**KIRKLEES METROPOLITAN COUNCIL
INVESTMENT & REGENERATION SERVICE**

DELEGATED DECISION TO DETERMINE PLANNING APPLICATIONS

Reference No: 2022/61/90097/W

Description: Reserved matters application pursuant to outline
permission 2021/93779 for erection of residential
development with parking and private landscaped
gardens

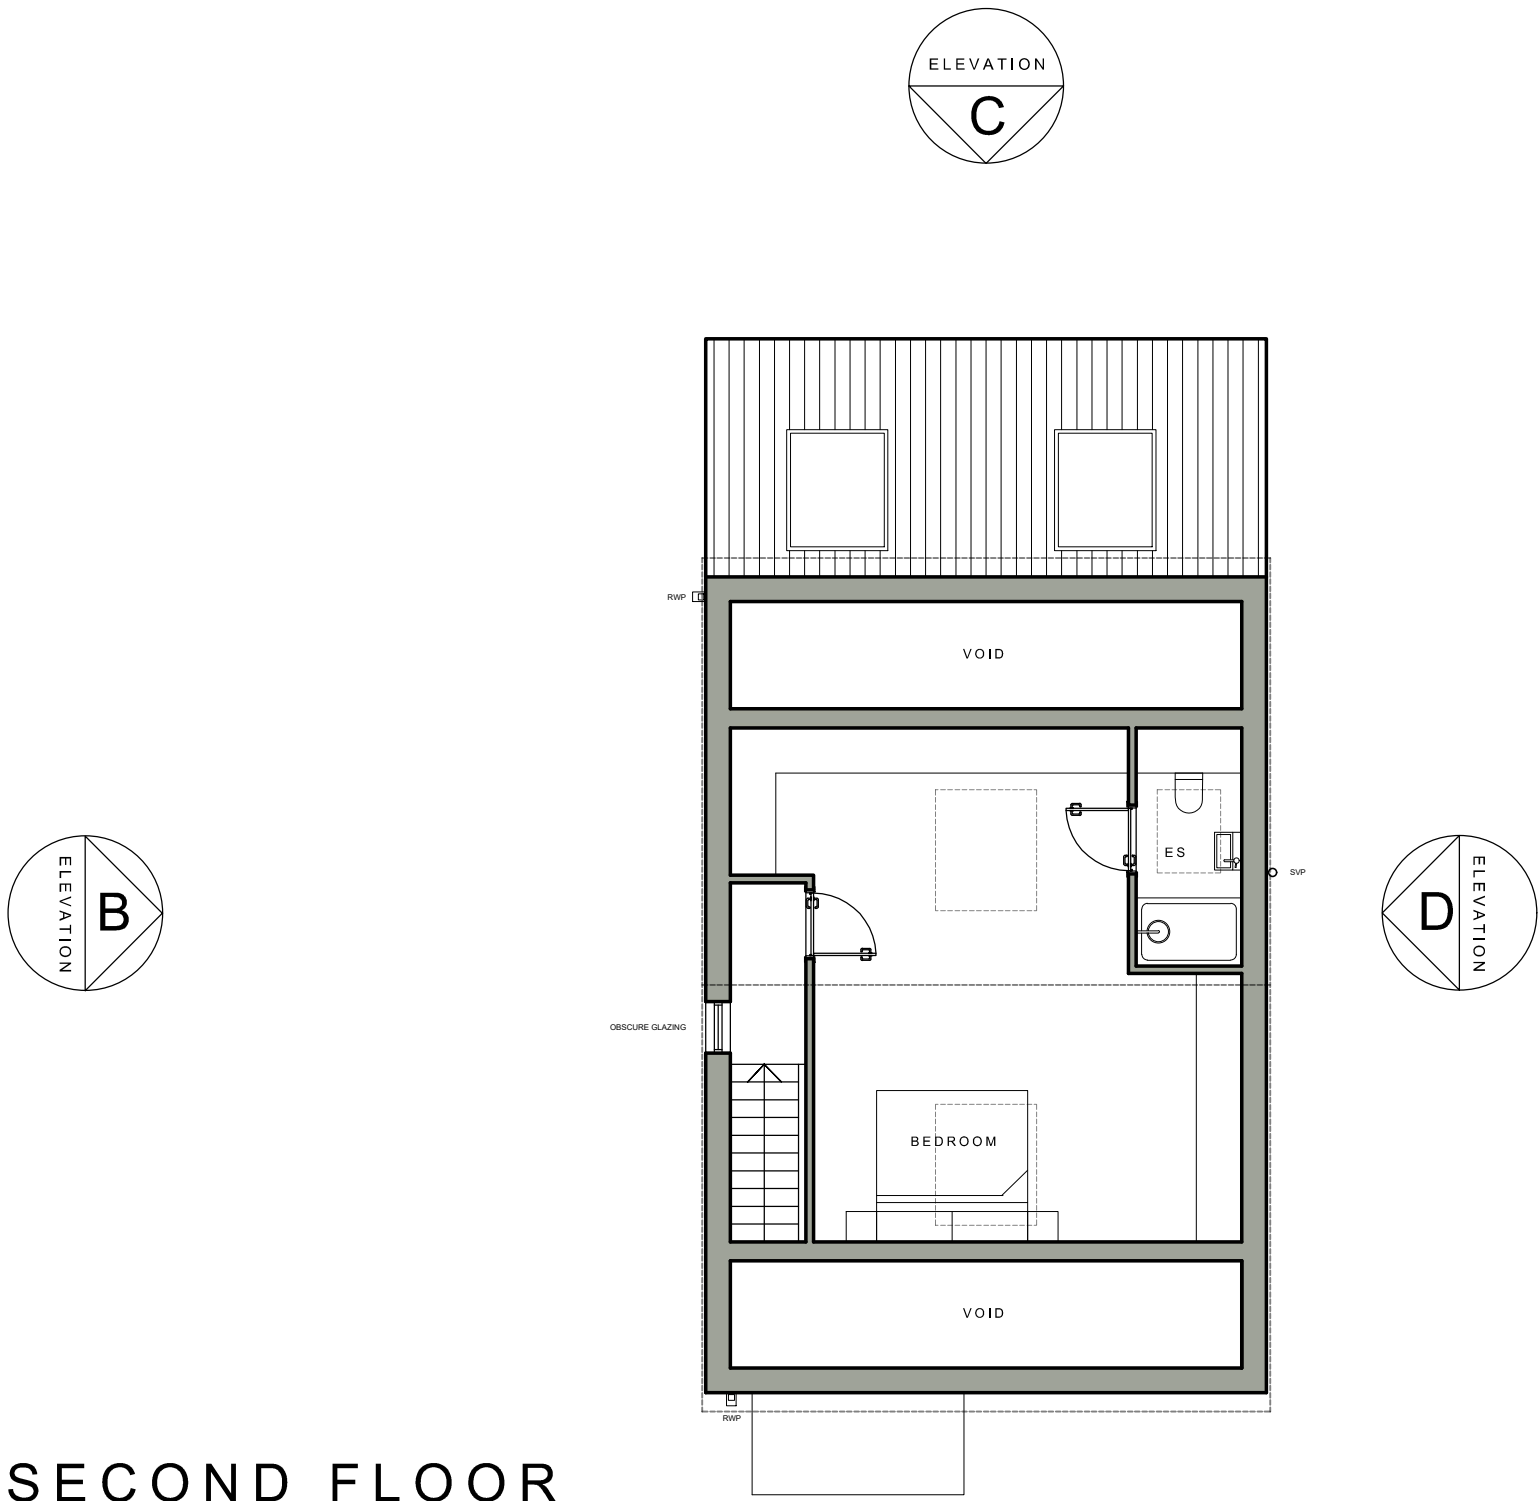
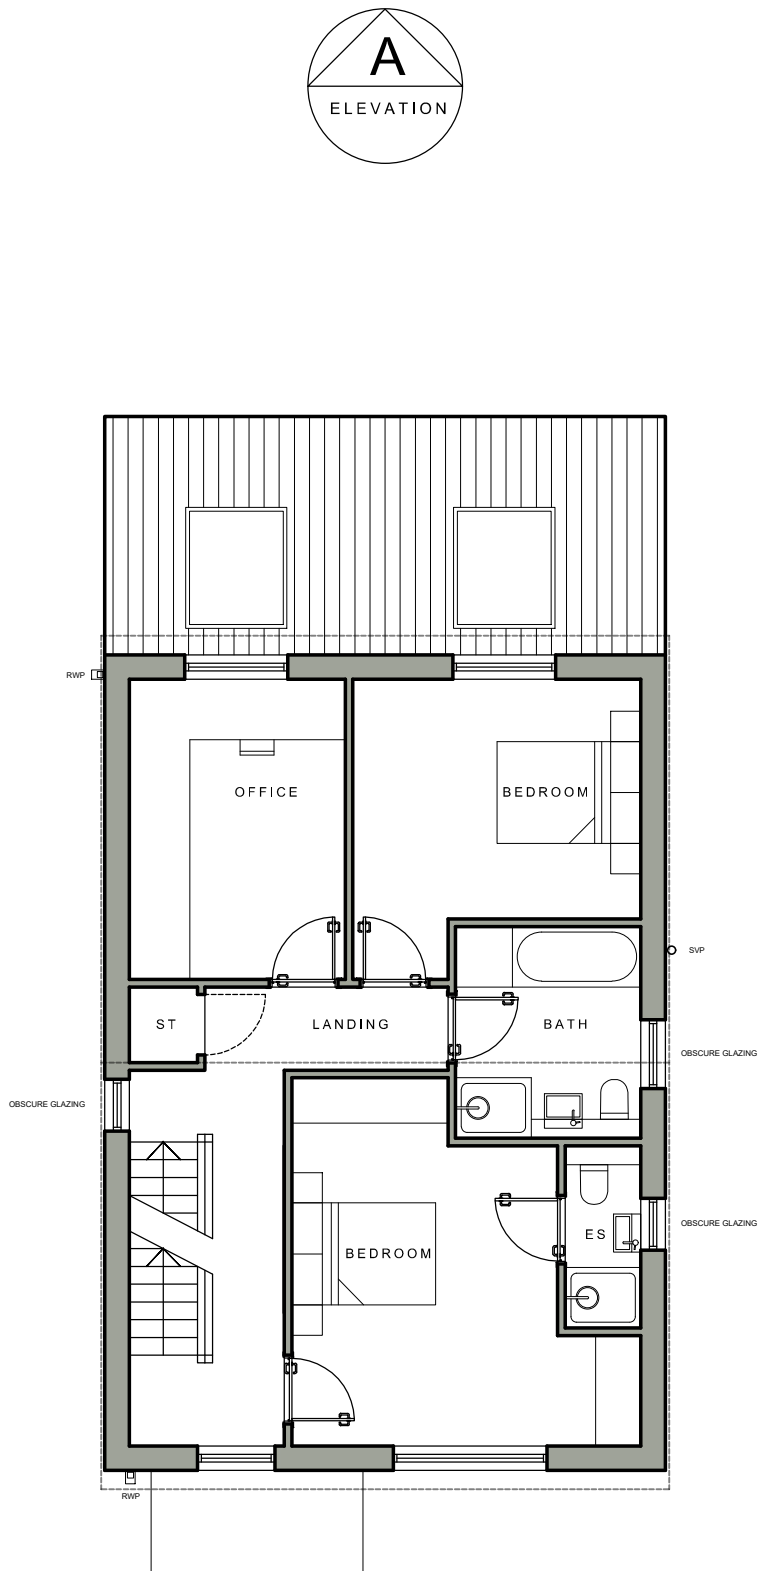
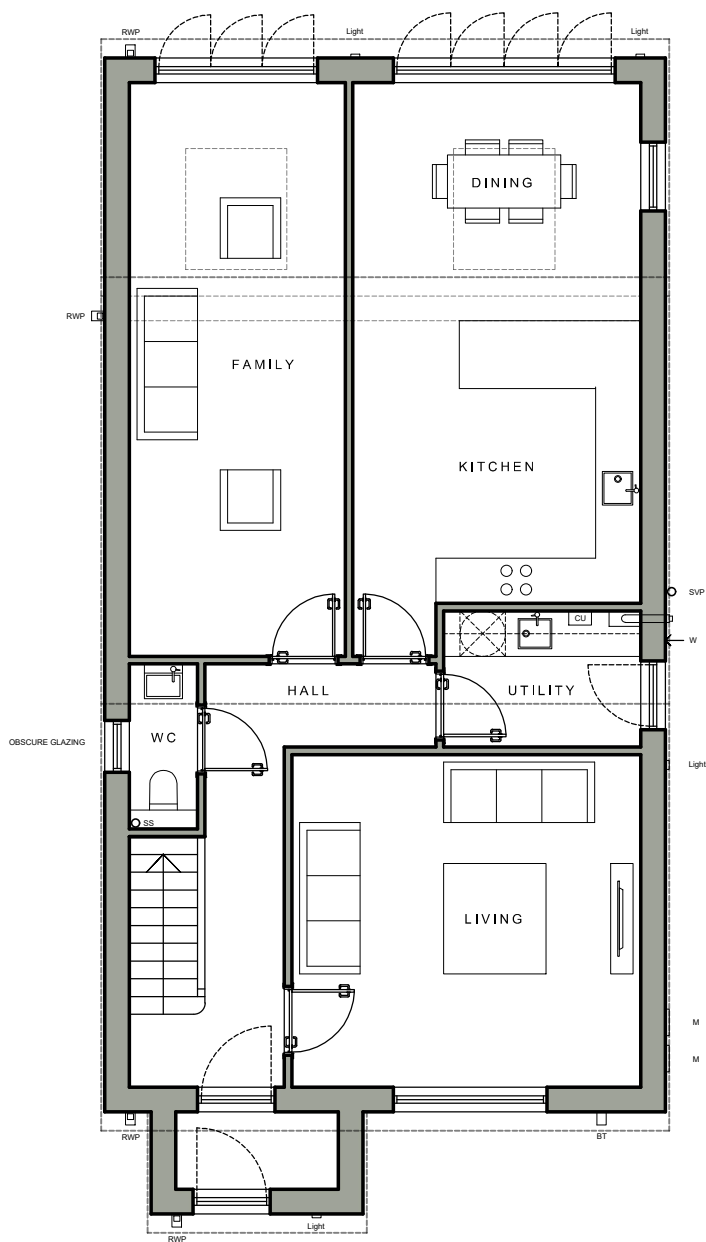
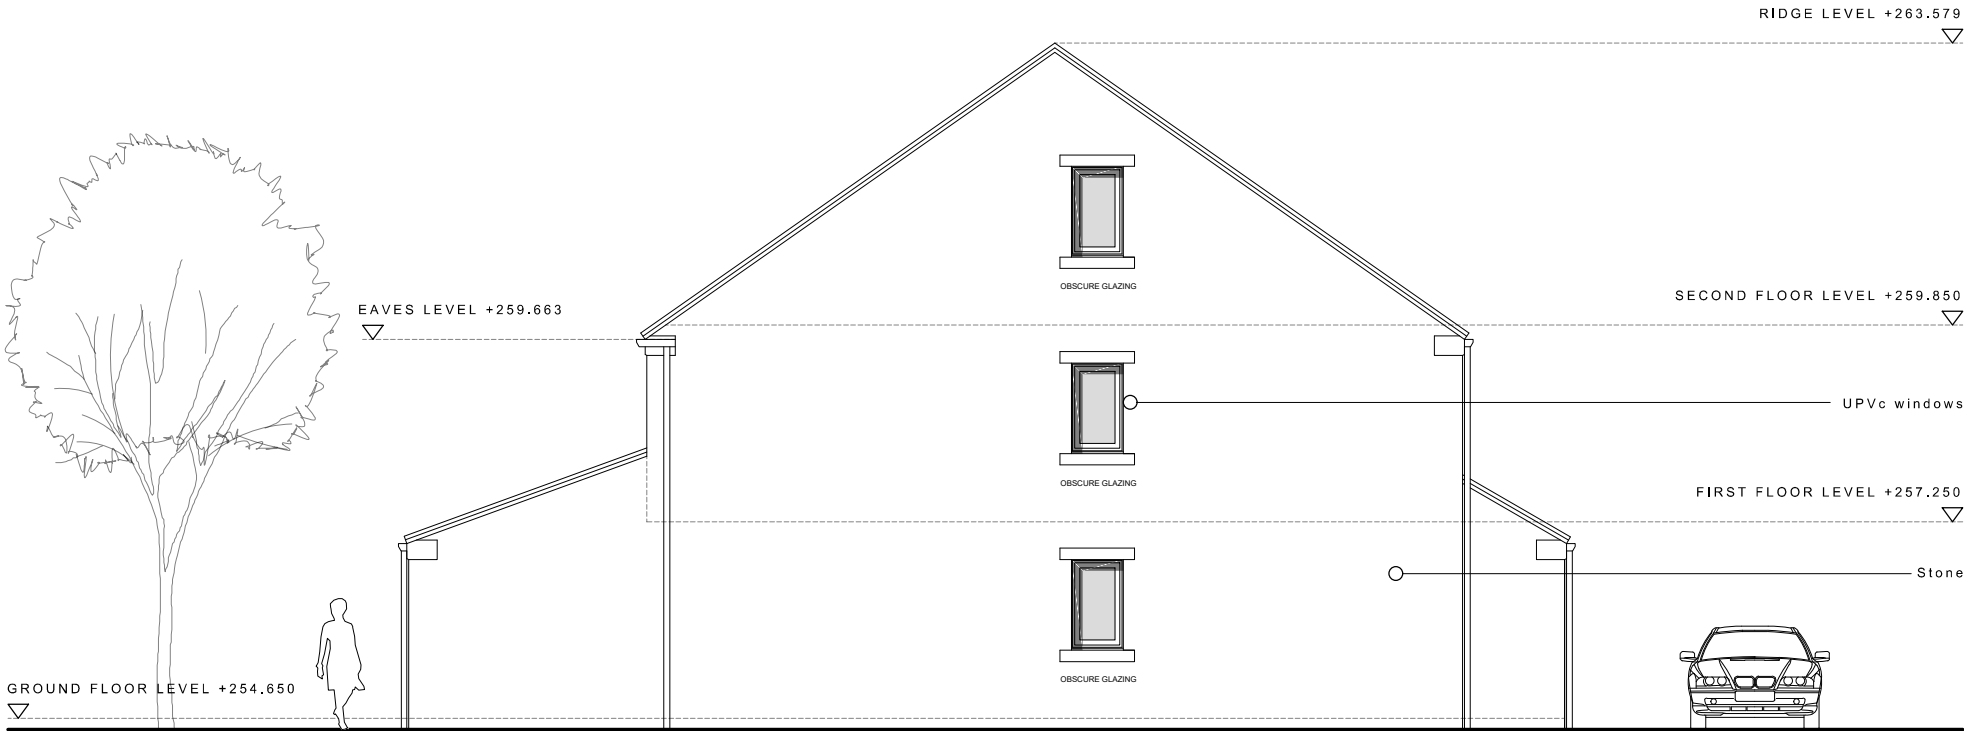
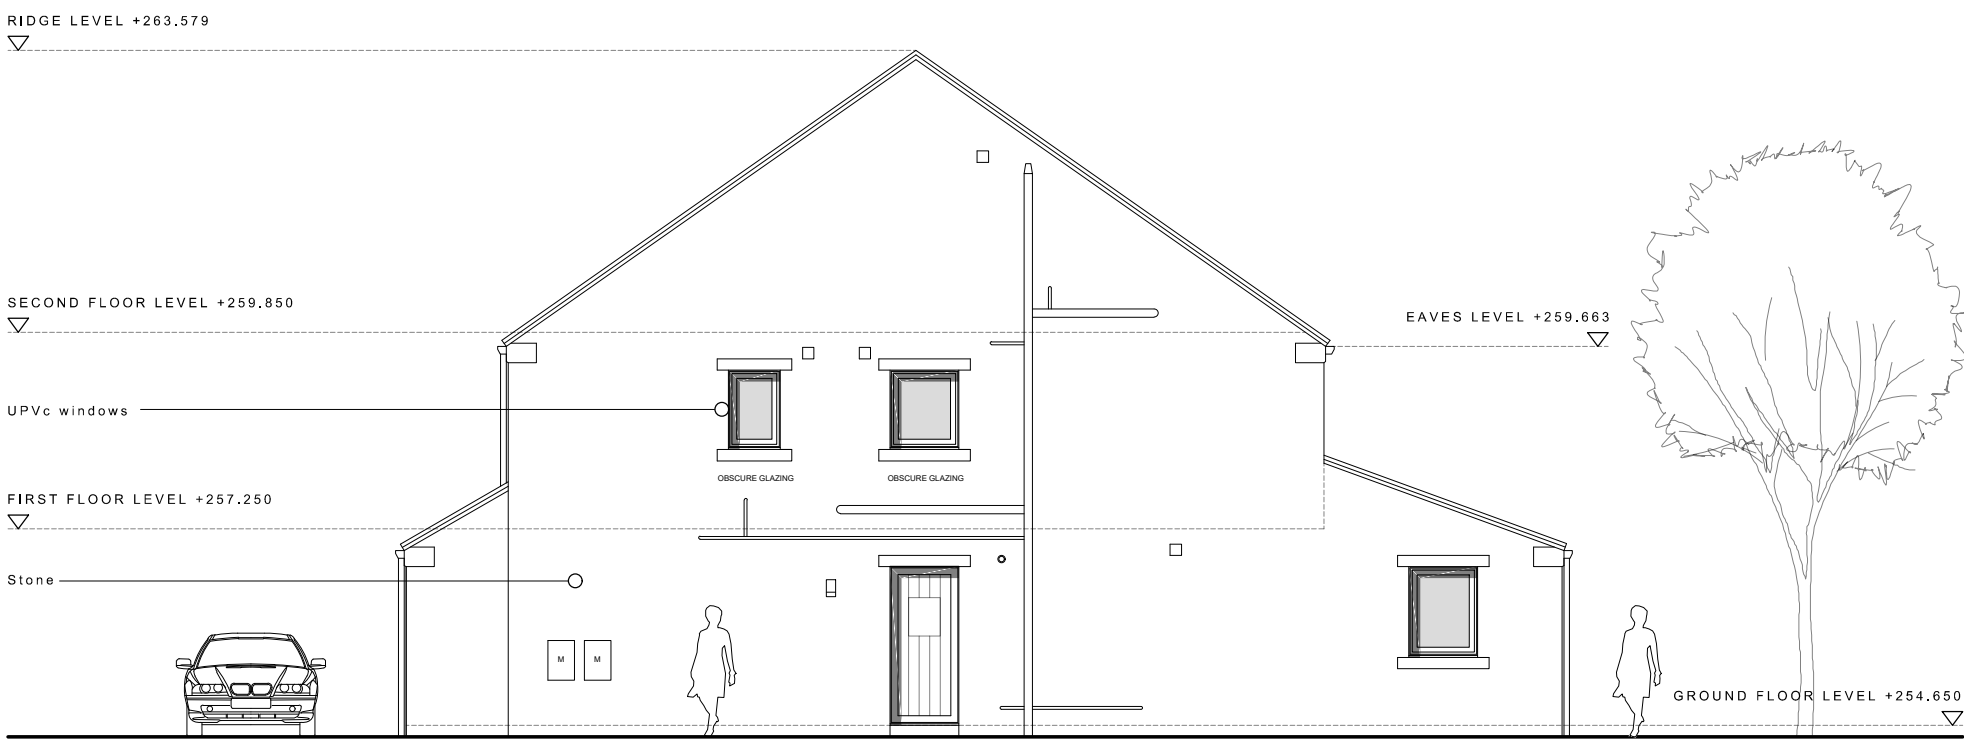
The case officer sought amendments to reduce the height of the proposed dwelling, so that it aligned with the eaves height of the neighbouring property to the south east (No. 134 Laund Road). In addition, the case officer sought amendments to the design of the proposed dwelling, seeking the removal of the originally proposed velux window to the front roof panel. Furthermore, the case officer requested that all of the proposed glazing be obscured to the side elevations of the dwellinghouse.

The applicant also submitted Dwg no. 2245-D-20-110REVD, which shows all of the windows the side elevations of the dwelling, except one, to be obscurely glazed. The one left clear glazed is considered acceptable from a residential amenity perspective.

In terms of overlooking, all of the windows proposed to the side elevation facing towards this existing property will be obscurely glazed. Therefore, these windows present no detrimental potential of overlooking, in turn, preventing any significant loss to residential privacy.

There will also be no material overlooking, as any windows adjacent to the side elevation of No. 134 will be obscurely glazed. The proposed clear glazed window to the rear side elevation of the new property is adjacent to the detached garage structure within the curtilage of No. 134, therefore, considered to lead to no significant impact due to overlooking. It has also been noted that there is substantial boundary treatment in place along the south eastern boundary of No. 134, in the form of wooden fencing, this will further mitigate any potential loss of privacy.

The applicant successfully submitted amended plans which reflected the recommendations set out by the case officer. The applicant submitted Dwg no. 2245-D-20-111REVA, which appropriately shows the eaves height and maximum height of the proposed dwelling in line with neighbouring property No. 134 Laund Road. This drawing also demonstrated the removal of the front velux window.

4. All windows annotated 'obscure glazing' upon submitted drawing titled 'Proposed plans and elevations' ref:- 110RevD shall be obscure glazed minimum grade 4. The obscure glazing shall thereafter be retained for the lifetime of the development.
